February 8, 2005

Re: Status of Improvement Permit Application #5-5-11184

On February 7, 2005 an Environmental Health Specialist from the Harnett County Health Department attempted to evaluate your property for the purpose of issuing an Improvement Permit. This individual was unable to evaluate your property for one or more of the following reasons.

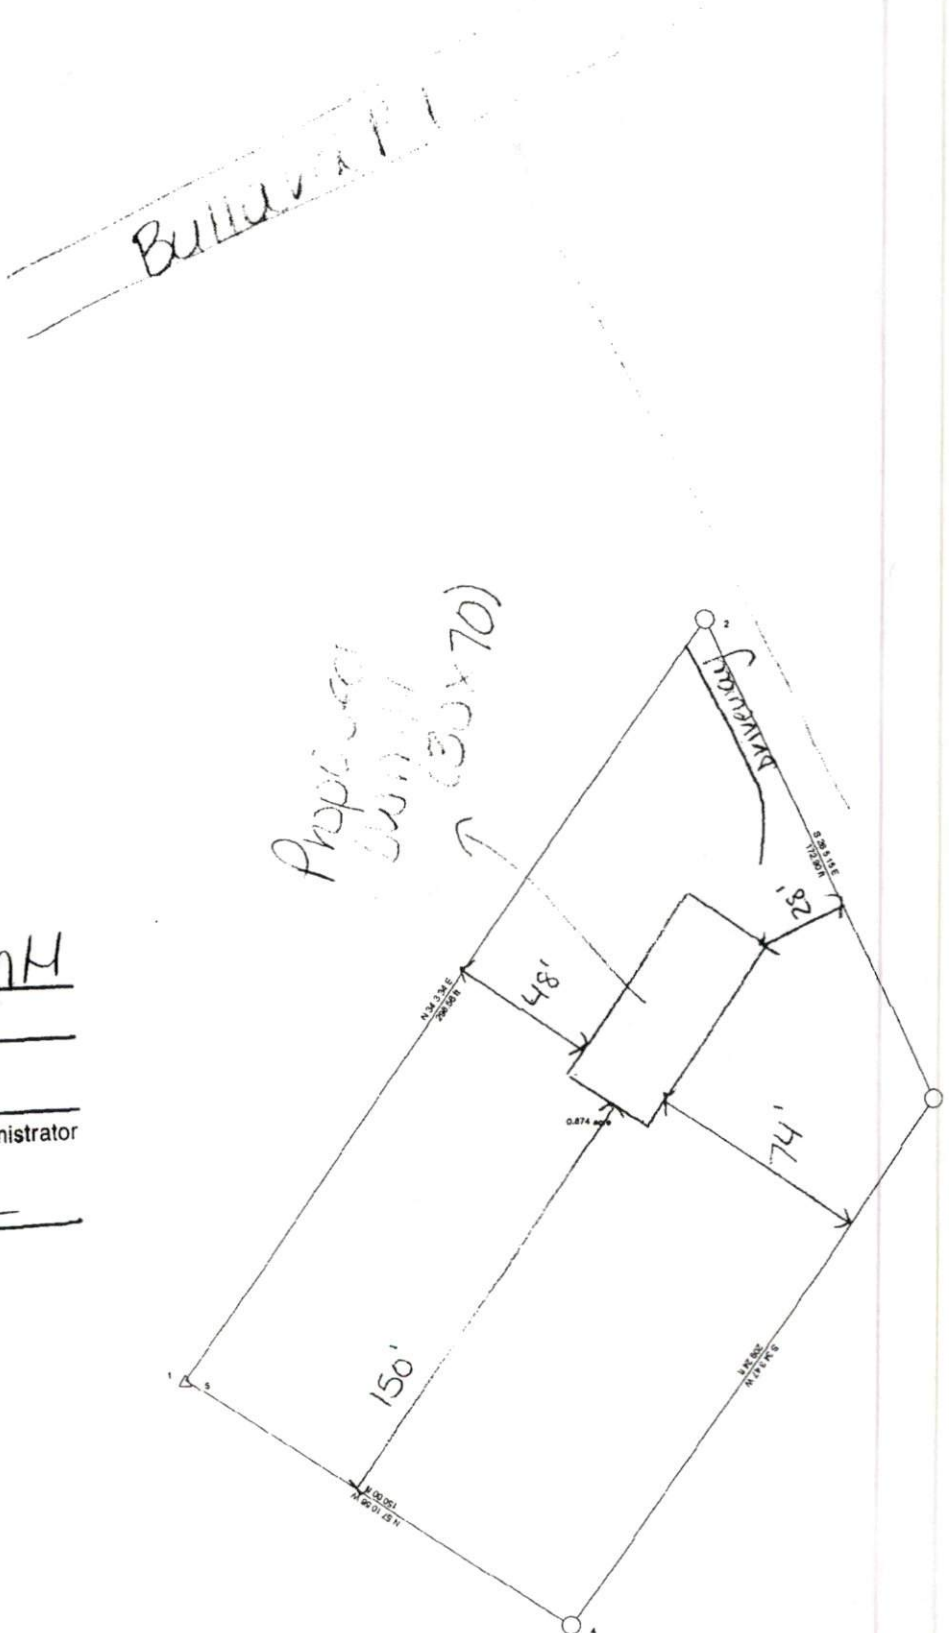
6. *Other Due to soil & site restrictions you will need to move your home site. You have 3 options – choose one option and submit changes to Central Permitting. You also have to reduce the number of bedrooms from 5 to 4. As you stated the 5th bedroom is to be an office, so please change at Central Permitting also.*
